Our Ref: EN010120

Date: 23 September 2022

Application by Drax Power Limited for an Order Granting Development Consent for the Drax Bioenergy with Carbon Capture and Storage project

Examining Authority's comments on Applicant's notification of potential change request, timetabling considerations, submission of environmental information and question in relation to use of section 106 agreements

Key:
 Order Limits
 Off-Site Habitat Provision Area

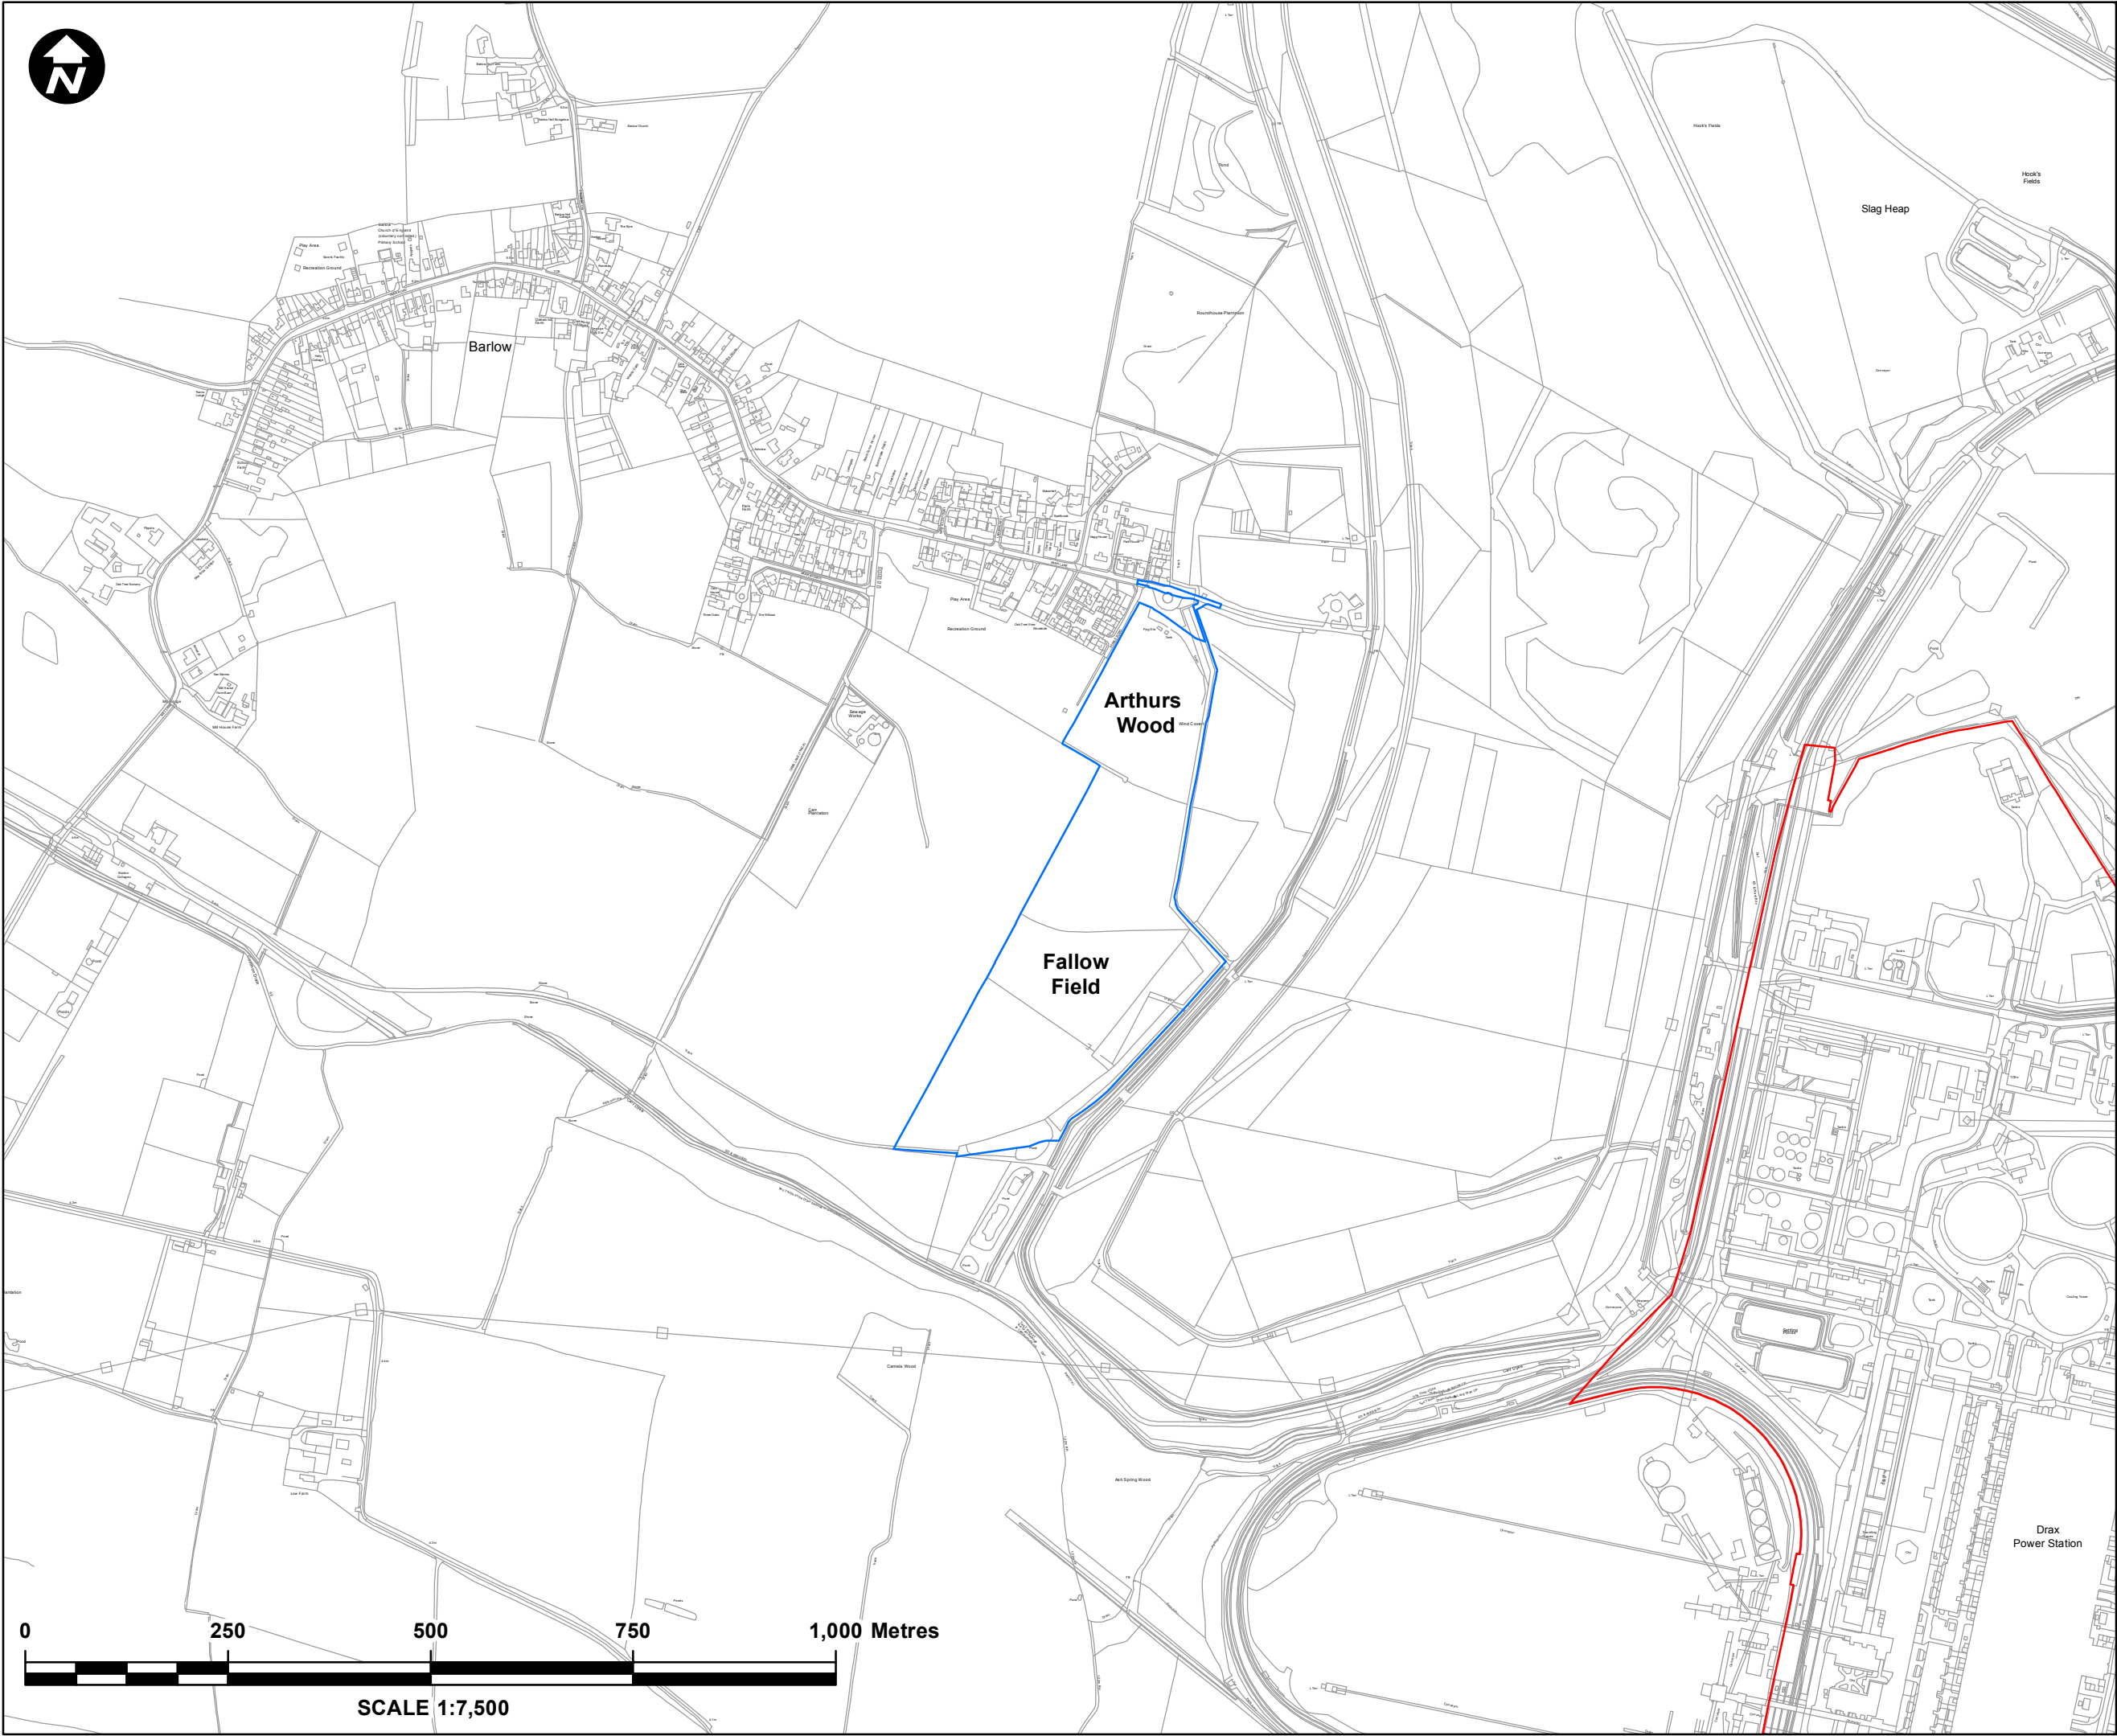
The ExA would like the Applicant to provide information on the approach taken to securing the Off-site Habitat Provision Area shown on Figure 1.3 [[APP-058](#)]. This land is not within the Order Limits and the provision of these works would be secured by way of a planning obligation under section (s) 106 of the Town and Country Planning Act 1990. Could the Applicant please respond to the following questions:

- What was the rationale in securing the provision of these works by way of a s106 agreement and not including this land within the Order Limits?
- Would it be more appropriate for this land to be included within the Order Limits including any Compulsory Acquisition of land and/ or rights and securing the works through the DCO?

- Would a s106 agreement satisfactorily secure the provision of the works and any maintenance?
- Does the use of a s106 agreement to secure the provision of these works accord with paragraphs 55 and 57 of the National Planning Policy Framework?
- When does the Applicant intend to submit a draft s106 agreement into the Examination?
